Our Ref: AL/110/10/NMA

**Application for Non-Material Amendment following a grant of Planning Permission
AL/56/08 - Fernfield Barn, Arundel Road, Norton**

PART NORTH ELEVATION

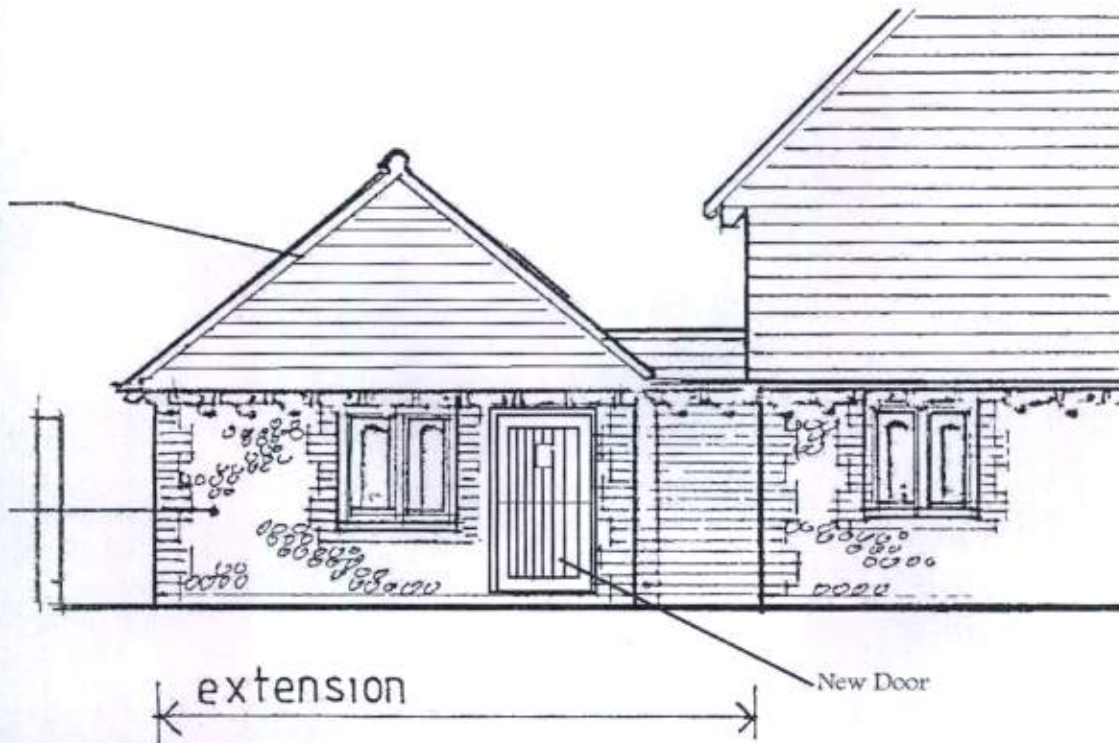
The changes identified namely an additional door on the north elevation and removal of one window to the proposed games room on the east elevation is acceptable as a Non-Material Amendment.
